*Ken Crawford
Retired Hydrogeologist
Former Principal Consultant
KLC Environmental Pty Ltd
October 2018*

Crawford Submission against the Vickery Extension Project

Vickery Extension Project Environmental Impact Statement Including Appendix C Flood Assessment

RAIL SPUR INVESTIGATION CORRIDORS

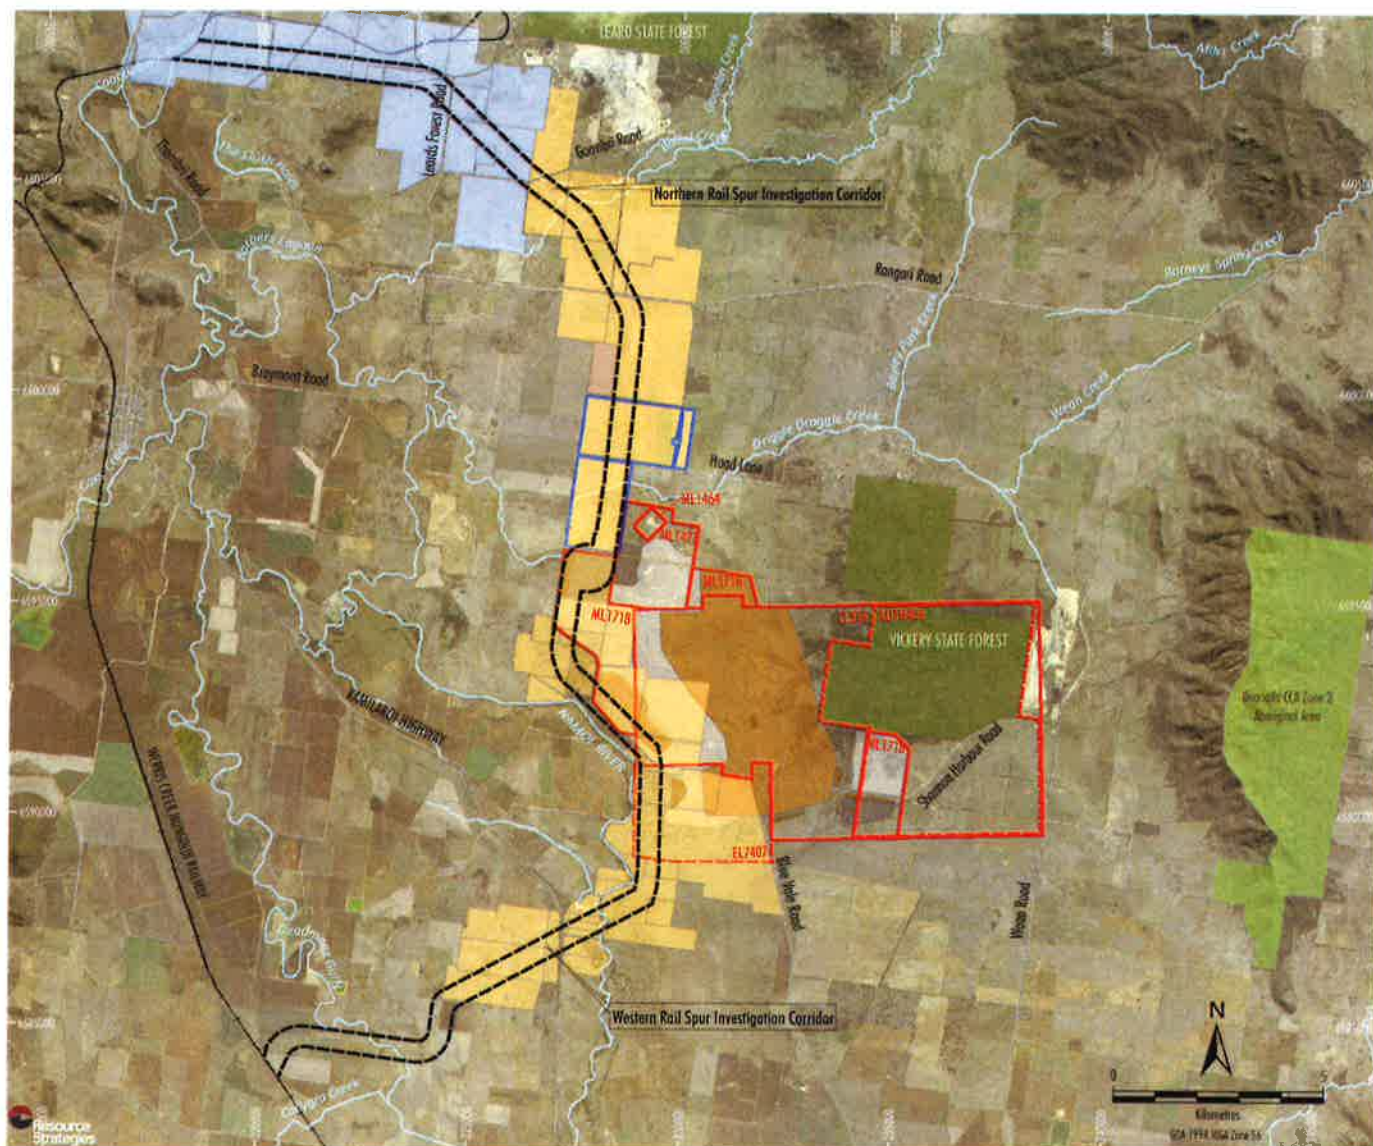
The Vickery Extension Project spur rail location does not comply with community expectations and surface and groundwater considerations. It will divert floodwaters because of its alignment and cross many ‘hotspots’ in the case study area. These ‘hotspots’ are covered in the Webb McKeon & Associates floodplain study (2005).

Figure 6.1 shows the alignment or location of the rail spur. Again I quote ‘The Project rail spur openings will be designed to satisfy the conditions of the draft FMP’. The draft FMP has not been gazetted and should not be used in any design modelling. It has not been ‘ground truthed’ properly as there are errors in the case study area.
